# CITY OF ALBUQUERQUE

April 11, 2018

**RE: Frito Lay Parking Expansion  
1550 Mission Drive NE  
Grading and Drainage Plan  
Engineer's Stamp Date: 3/30/18  
Drainage File: F16D051**

Based on the information provided in your submittal received 4/6/18, the grading and drainage plan cannot be approved until the following are addressed:

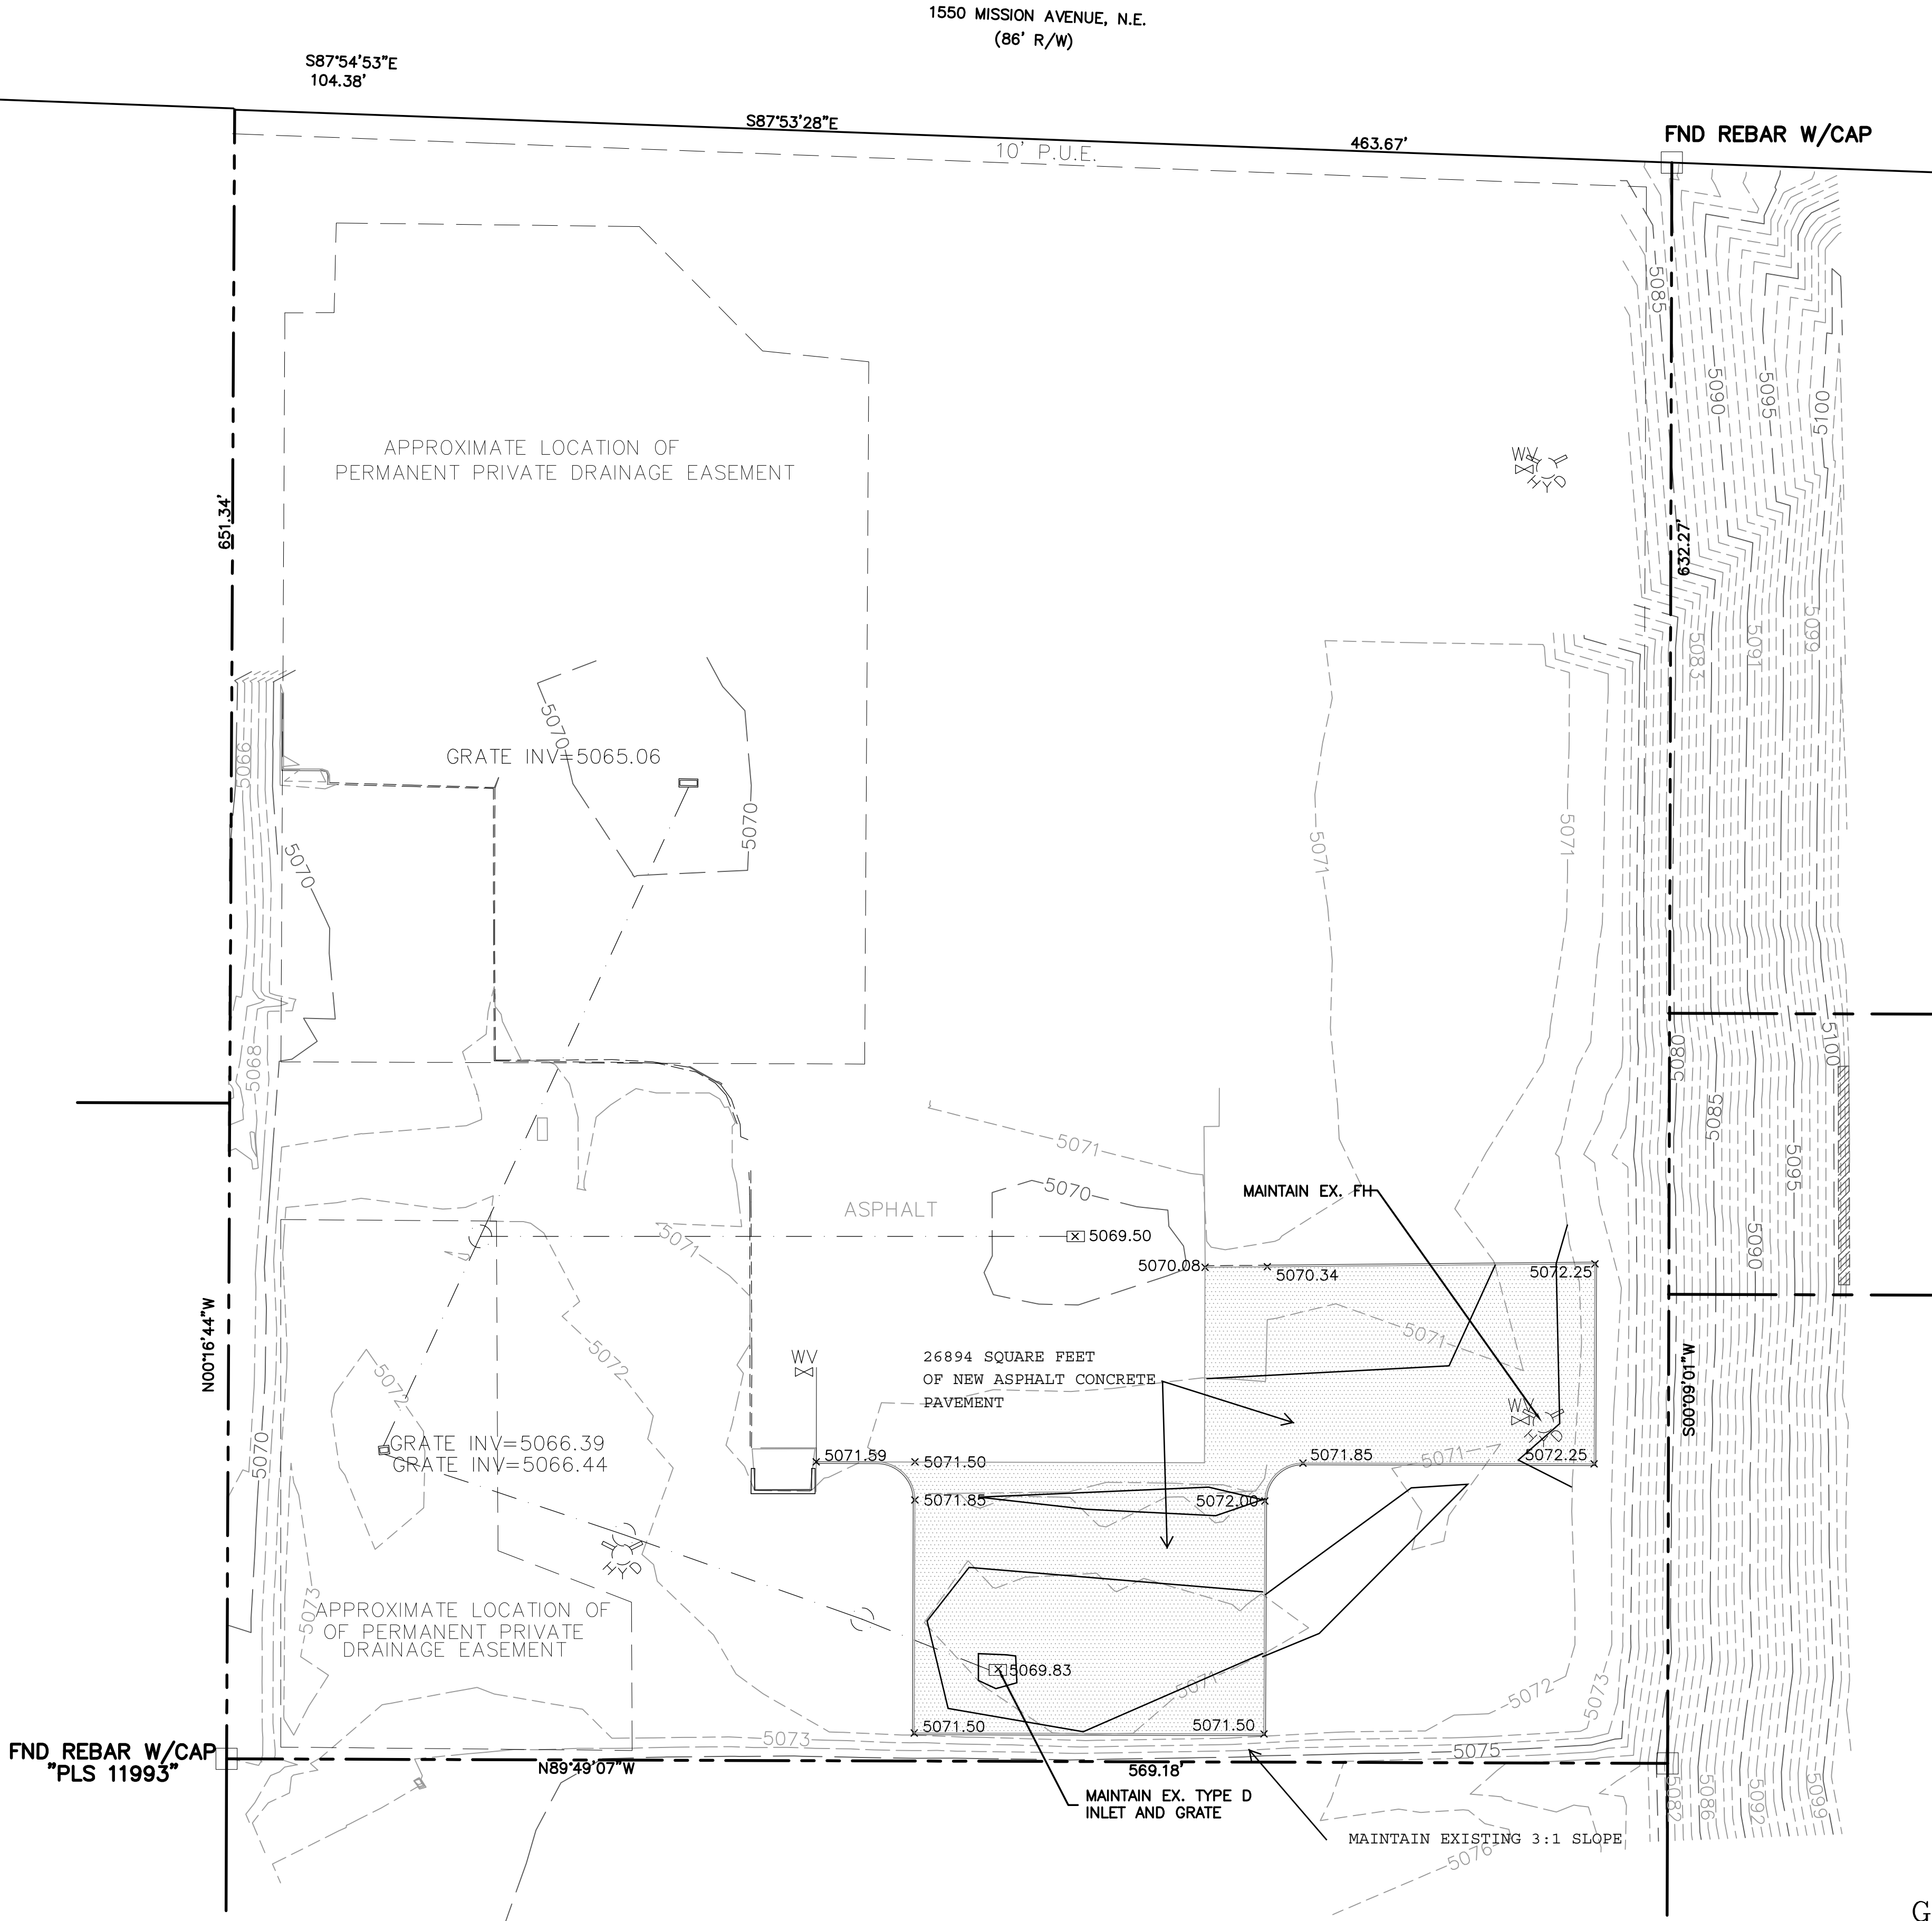
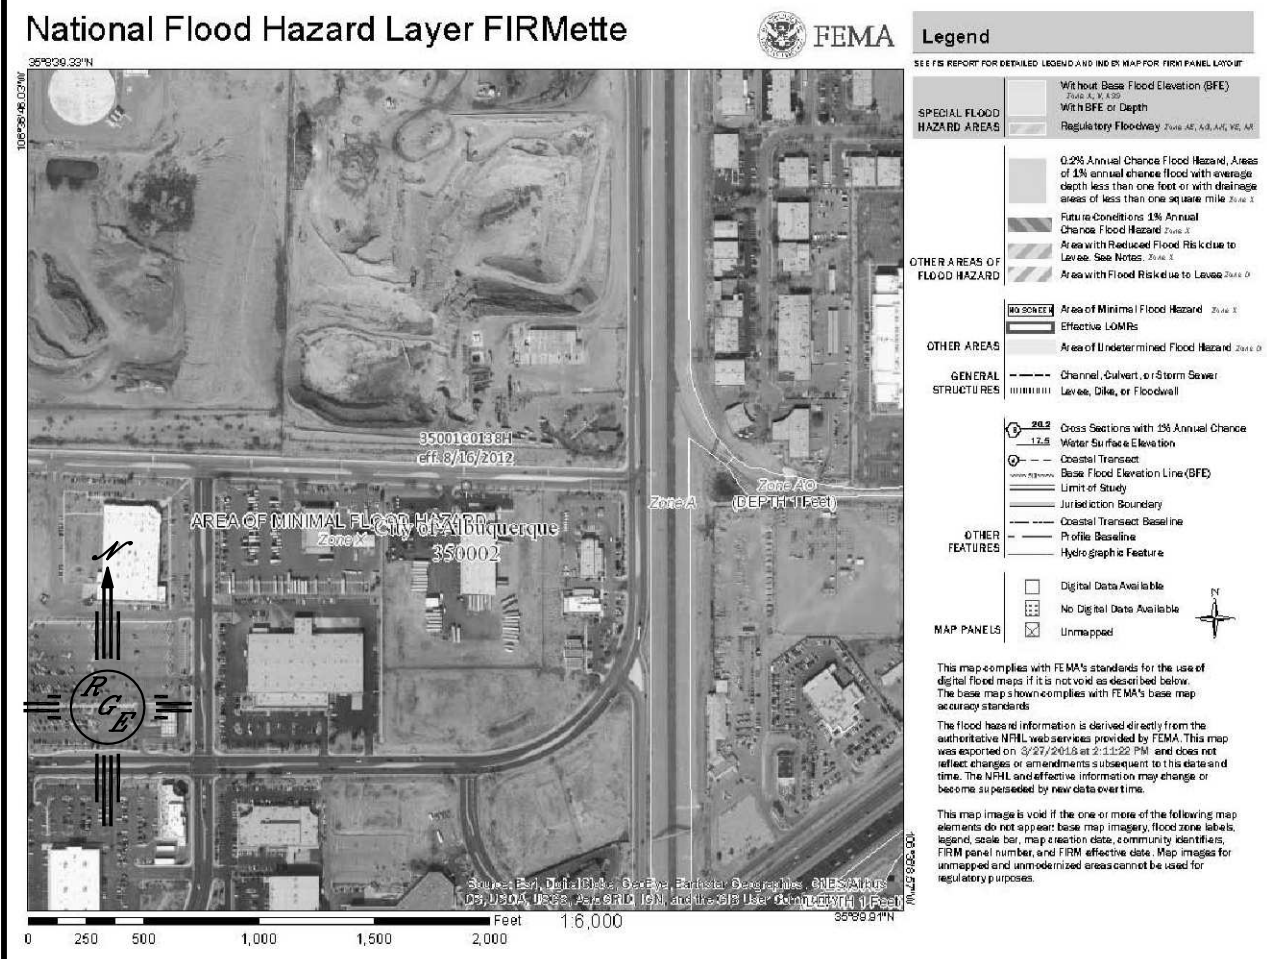
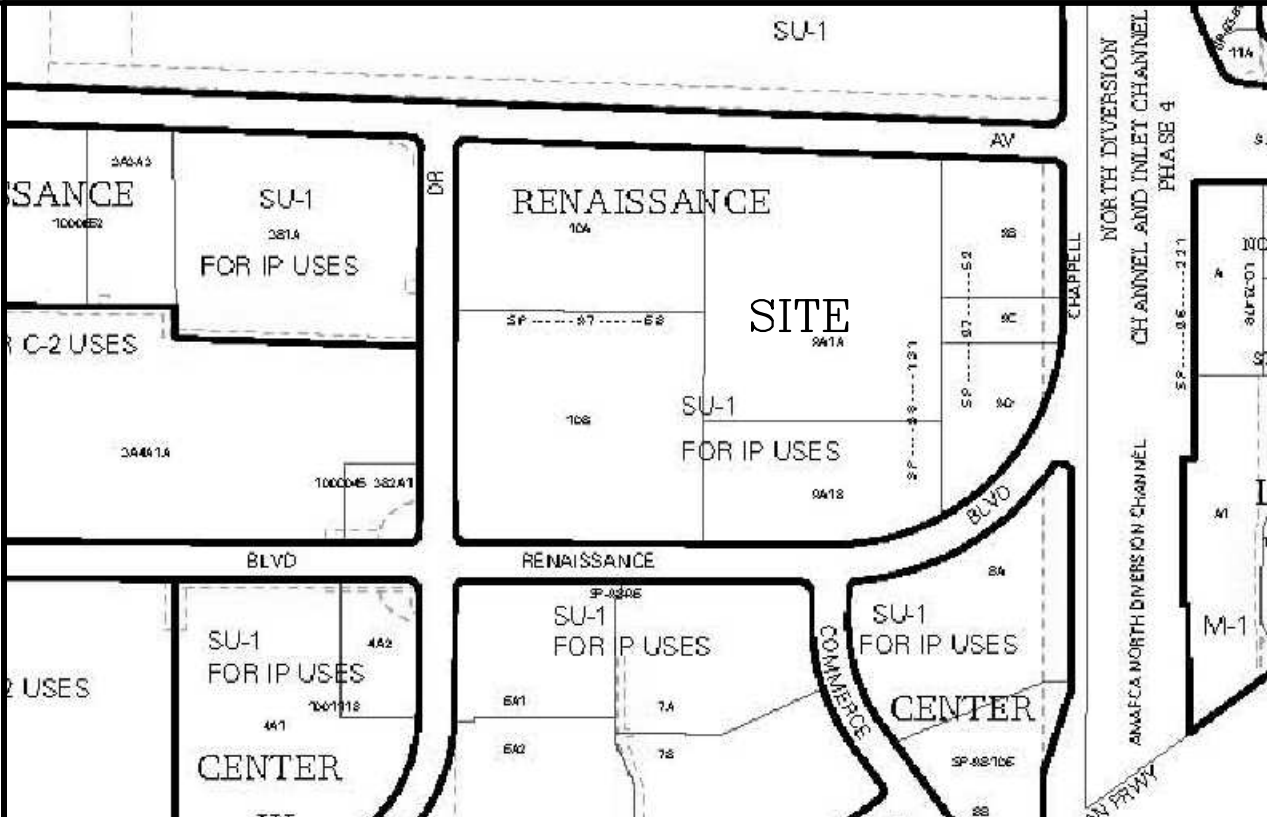
1. Show and state the areas of grading and new paving. Include proposed contours and proposed grading around the new parking lot.
2. Provide drainage calculations to support the first flush bypass volume.
3. Payment of Fee-in-Lieu will be required if not ponding on-site. Once the calculations are provided and verified, a treasury deposit slip will be generated for the bypass volume.
